From:
Sent: 01 December 2025 20:57
To: Farzana Tabasum
Subject: Formal objection to unsafe retaining wall 2025/45/90964/E

Formal Objection – Retaining Wall Submission (Condition 16)

2025/45/90964/E

Land off Westgate Cleckheaton bd19

SECTION 3-3
1:25

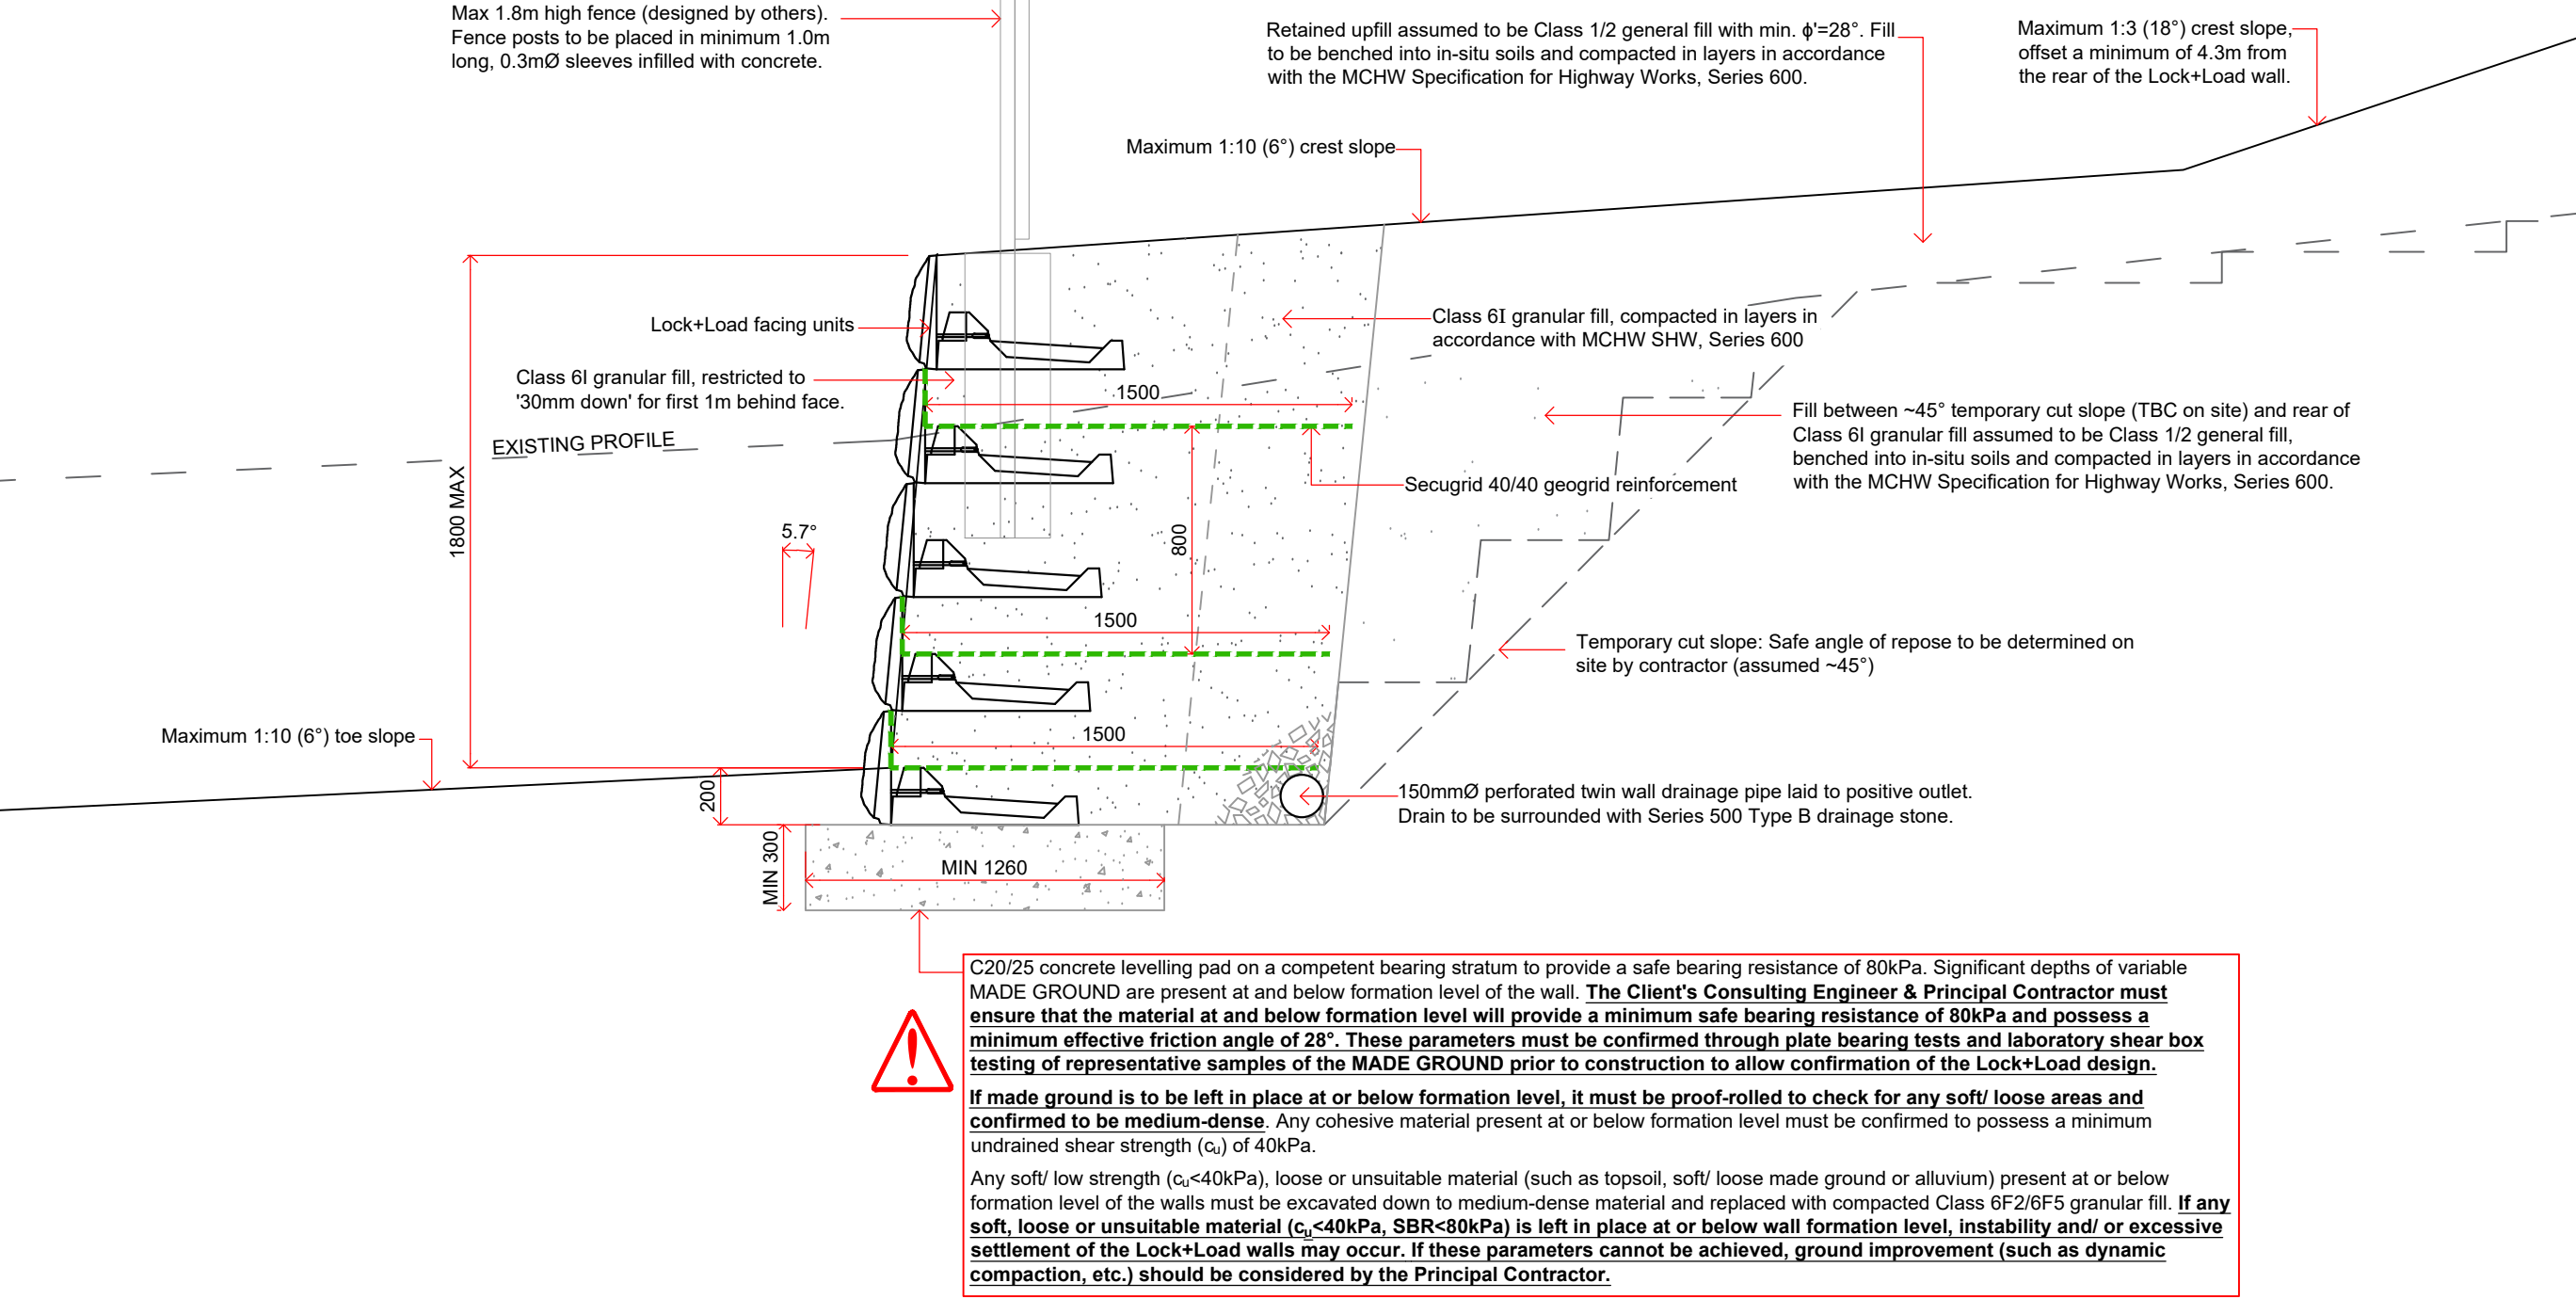
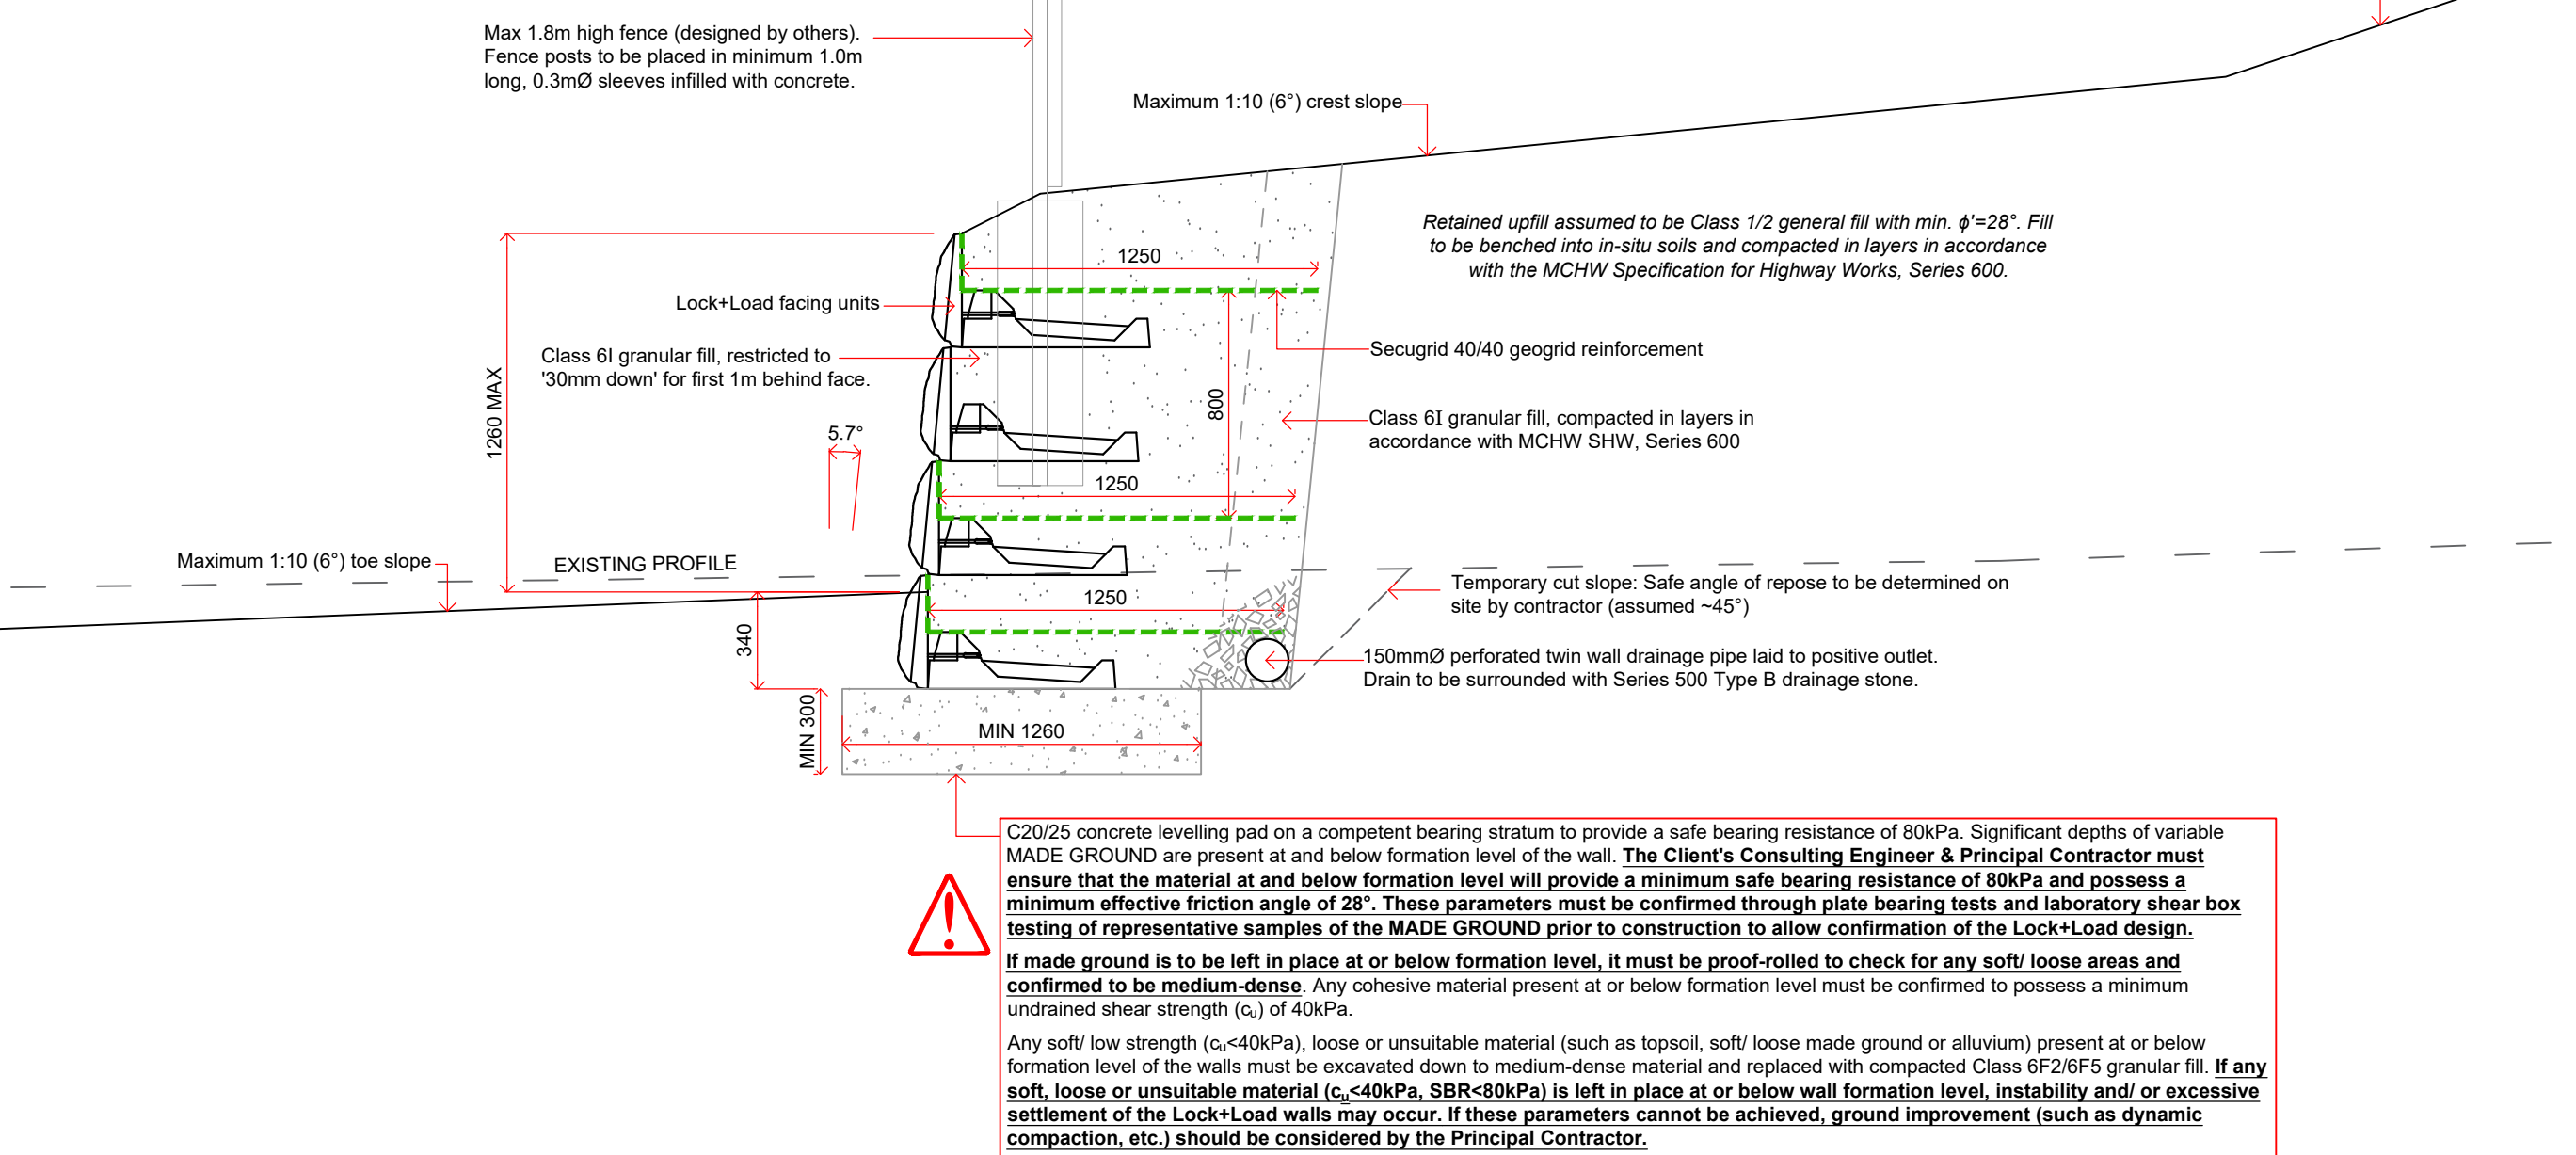
The drawings even contain a note requiring these checks to be carried out, yet they have not been completed. This omission is extremely serious given that the ground at this boundary is weak, variable and partially unstable, with collapsing trial pits, rapid groundwater ingress and inconsistent made ground containing ash, clinker, slag, brick dust and industrial waste.
